Your Ref: OWPC14713
Our Ref: BR/194/17/PL 30-06-2017
Please ask for:
Richard Temple

Demolition of the existing Foreshore office & decommissioning of existing underground toilets. New purpose built unisex toilet block including urinals, baby changing facilities & accessible WC, plus a separate beach office with public information point & first aid facilities. All located on the existing seafront promenade.

Promenade Opposite Clarence Road The Esplanade Bognor Regis

Thank you for your internet representation made on 25th July 2017 which has been recorded as **'an objection'** with the comments as follows:

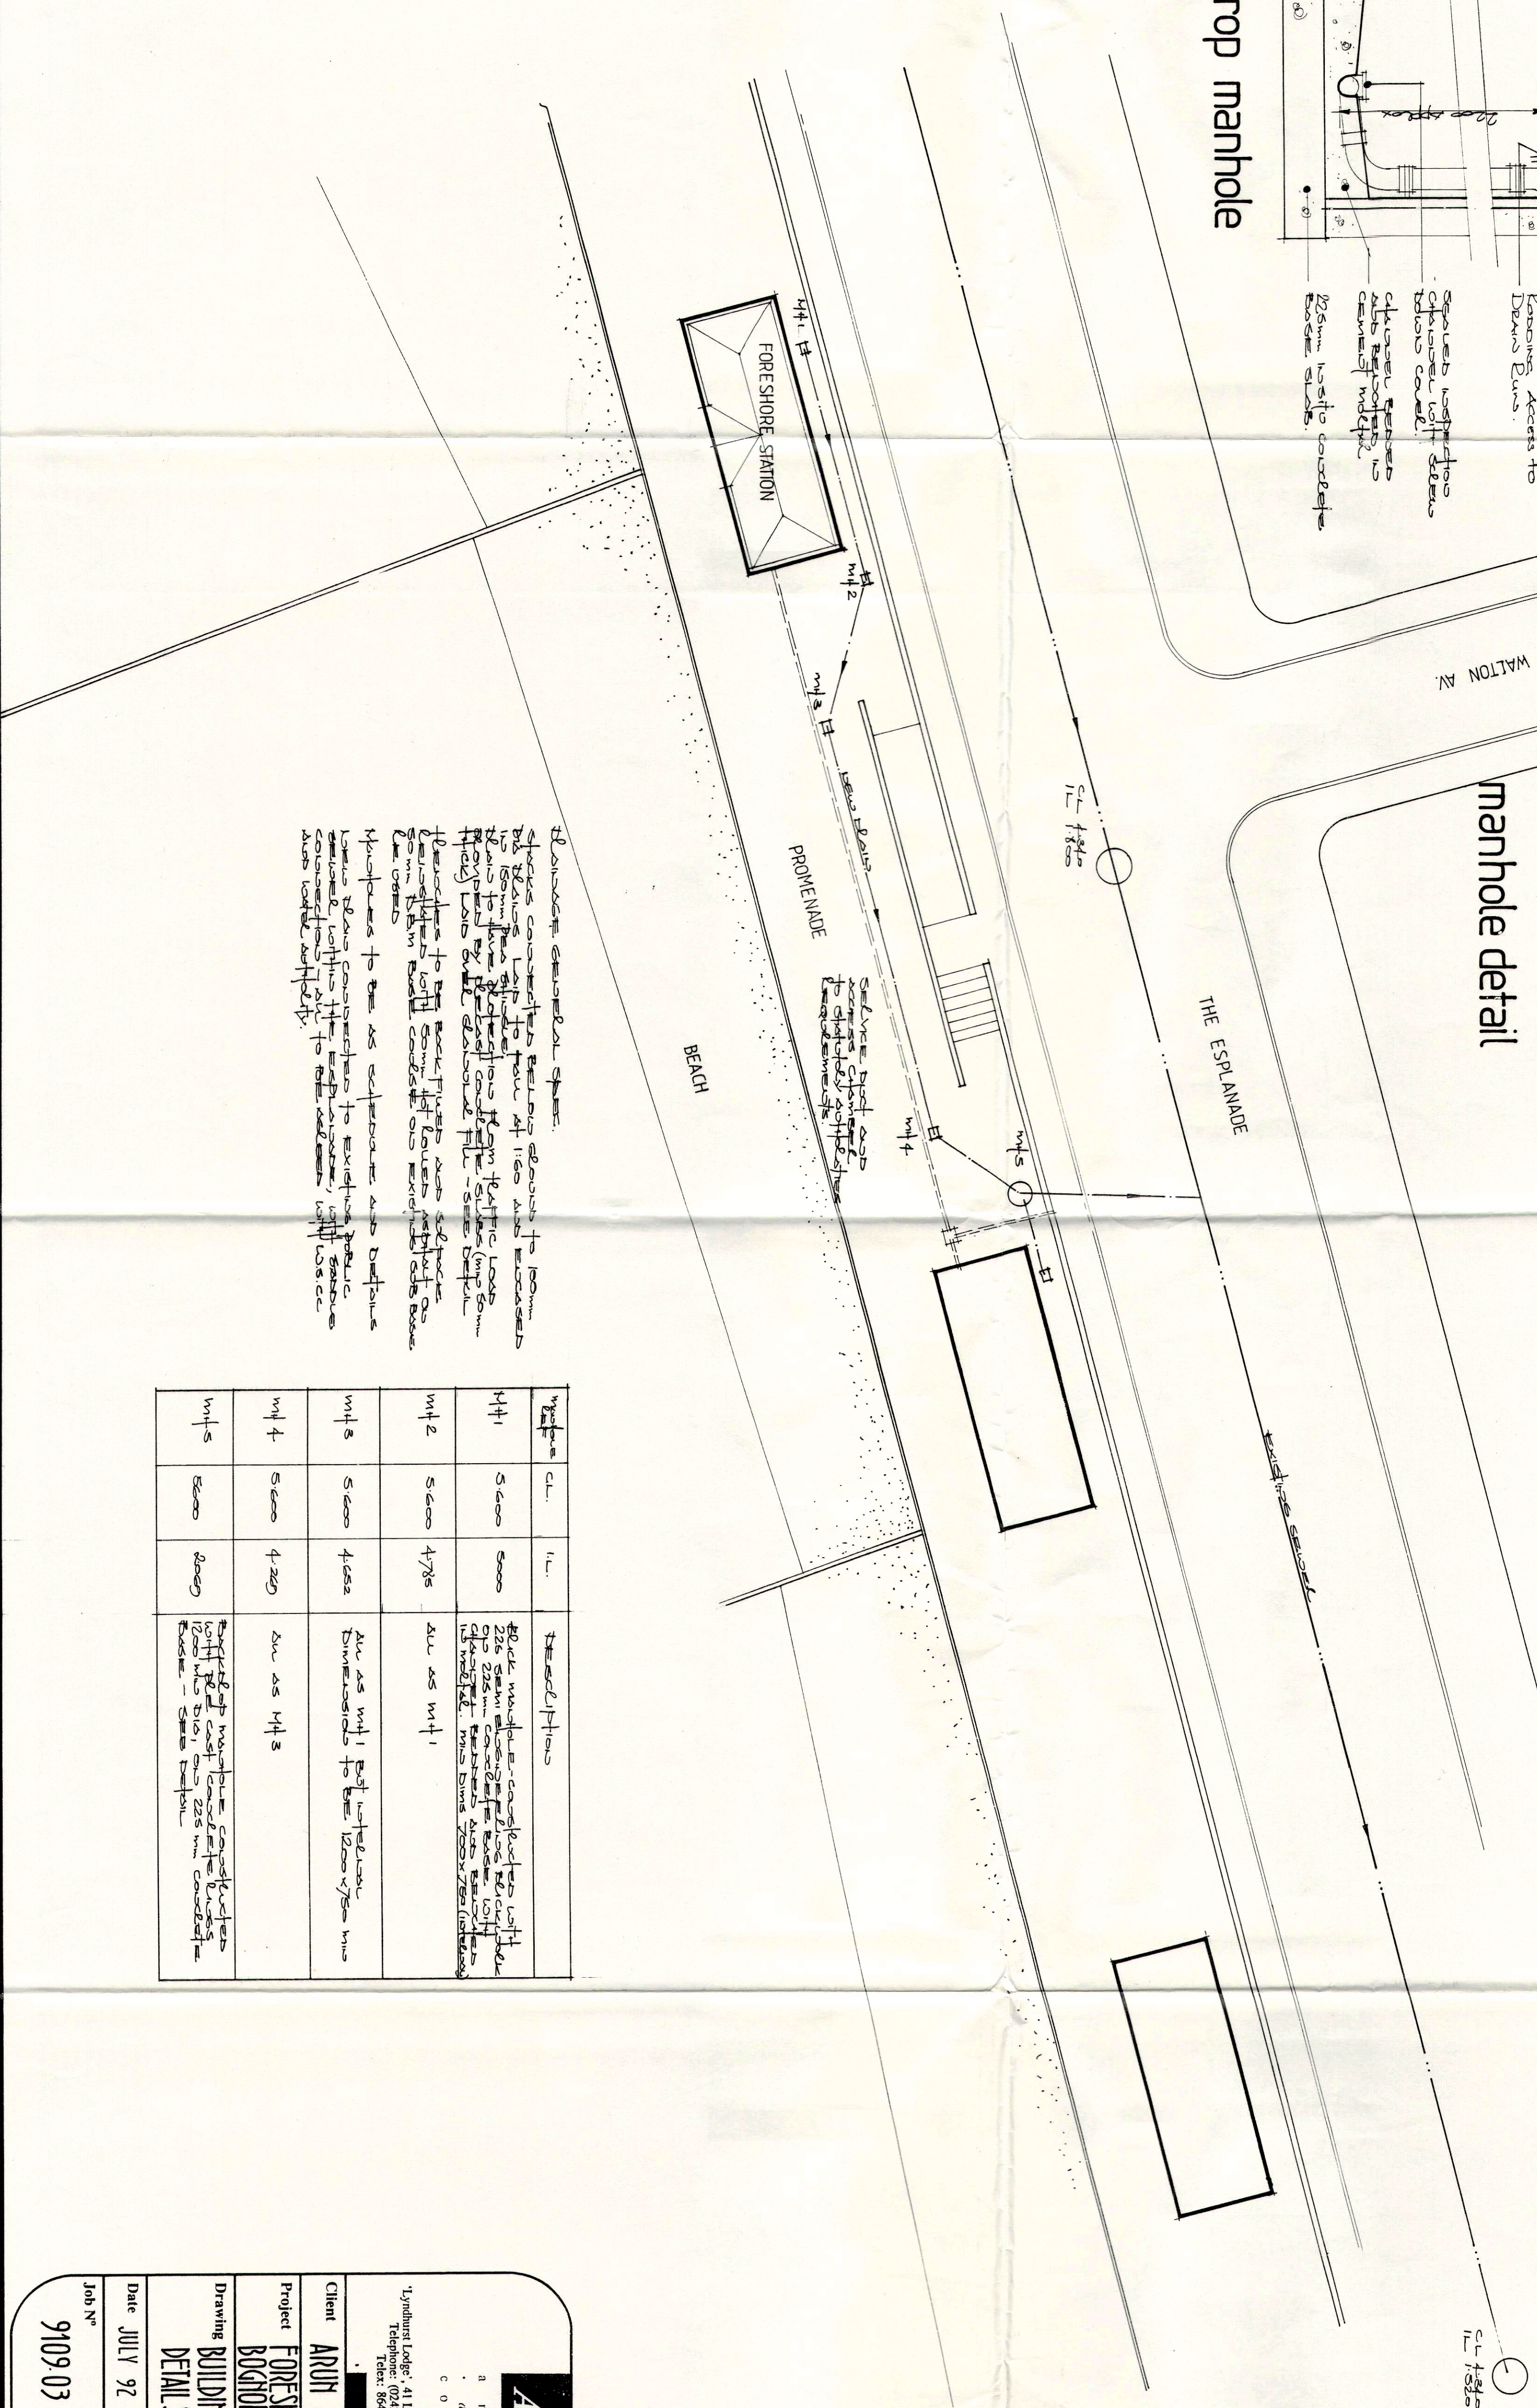
(3) ASSESSMENT and FLOOD RISK (12) Question How will surface water be disposed of (possible meaning the Rain water from gutters or roof)? ADC Answer Pond/Lake ? there is neither on The Esplanade ?

DRAWING
Proposed Toilet Elevations

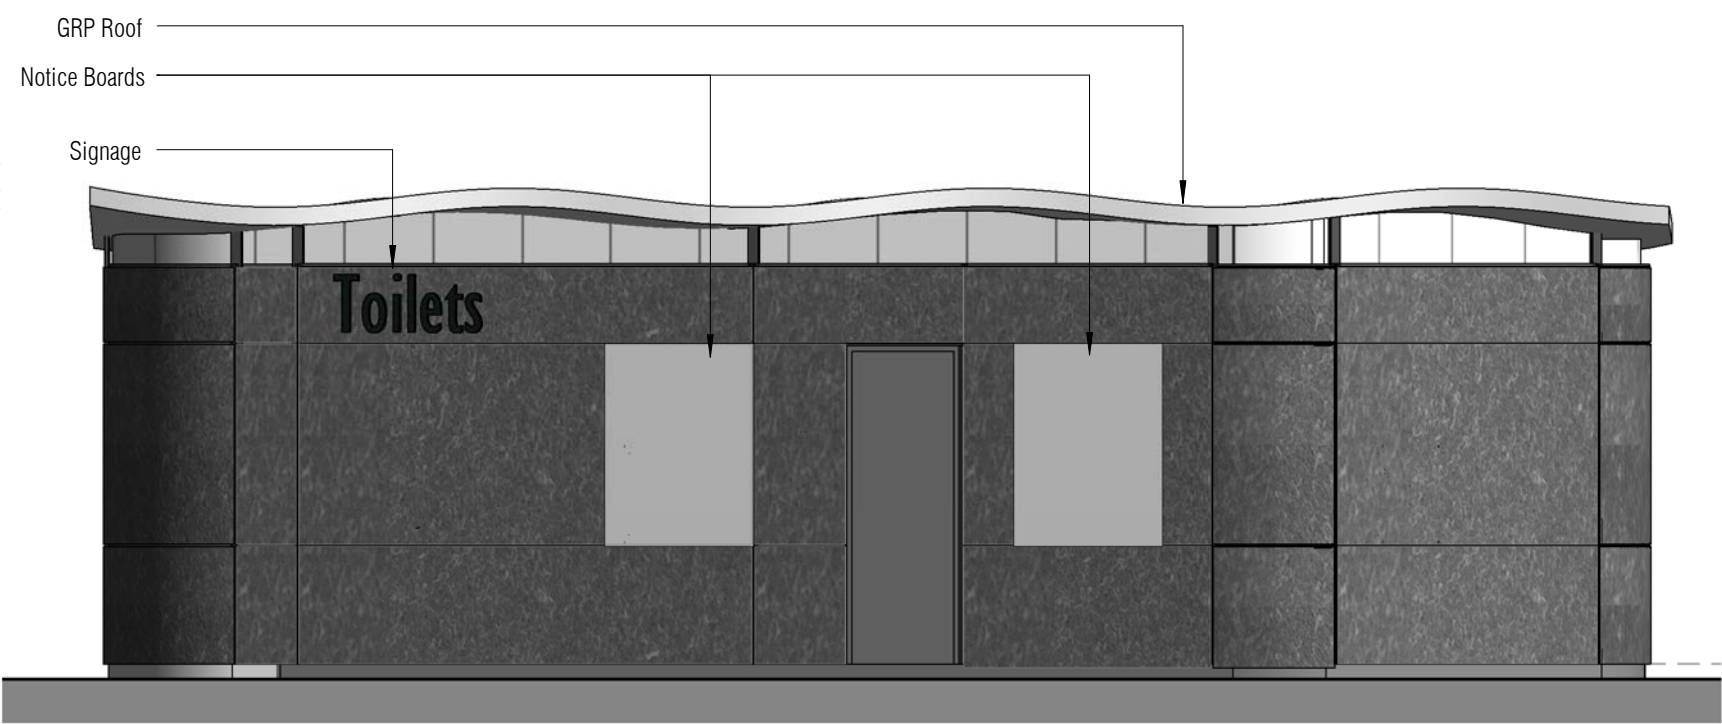
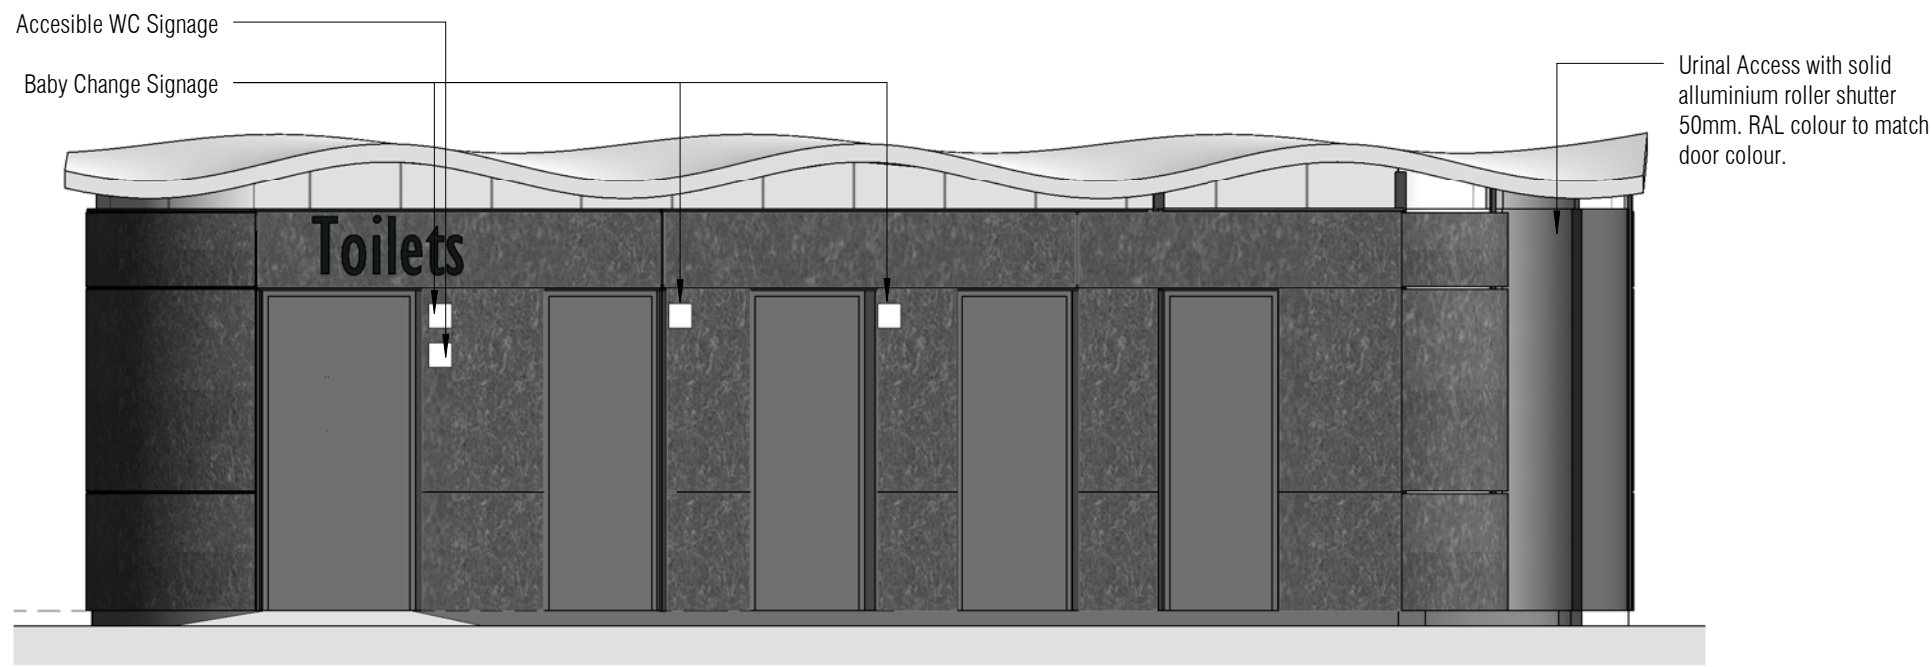
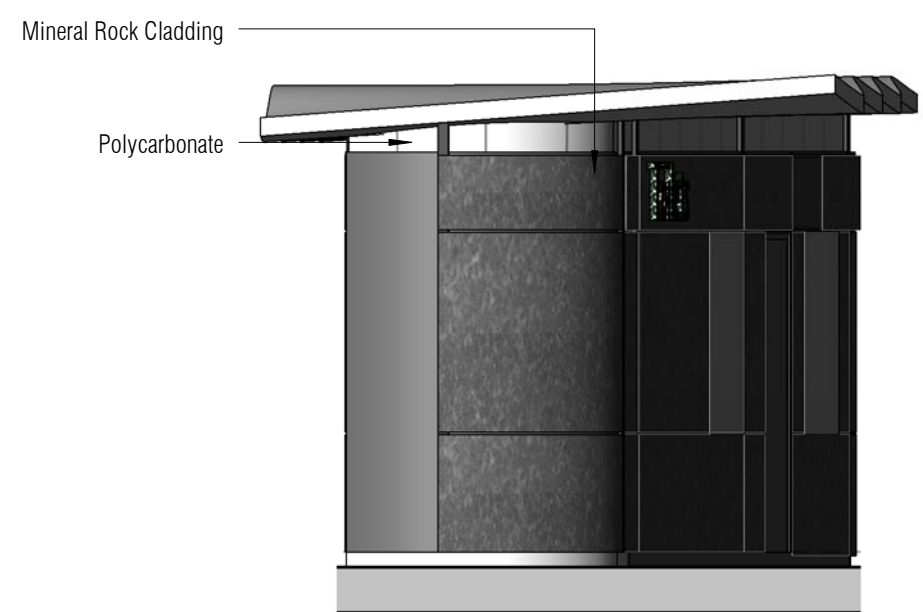
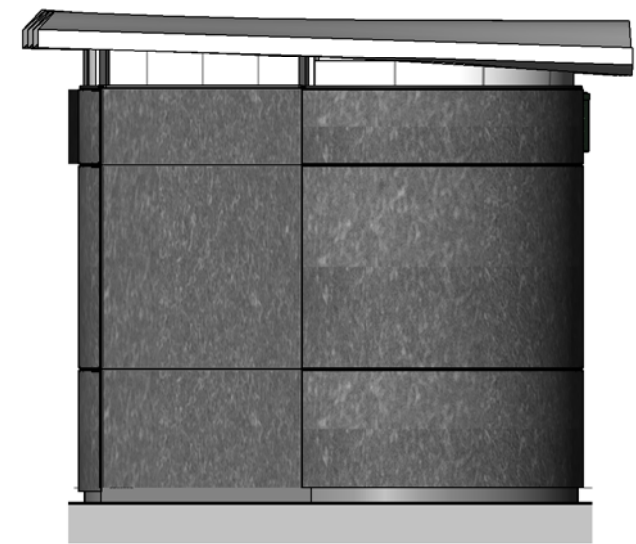
(2) The Construction and Design are NOT appropriate for BOGNOR REGIS. BR/194/17/PL states Metal and Steel will be used within and hidden within the walls of the building. the Roof with its RAISED wave feature Will ATTRACT both SEAGULLS and PIGEON to roost which in turn means ADC will be placing netting etc which will take AWAY the PROPOSED THEME ?

IN NO WAY are SOUTH FACINGS DOORS acceptable to the environment of THE ESPLANADE should the LOCATION and CONSTRUCTION only be suitable for SOUTH FACINGS DOORS this BUILDING is NOT FIT For PURPOSE.
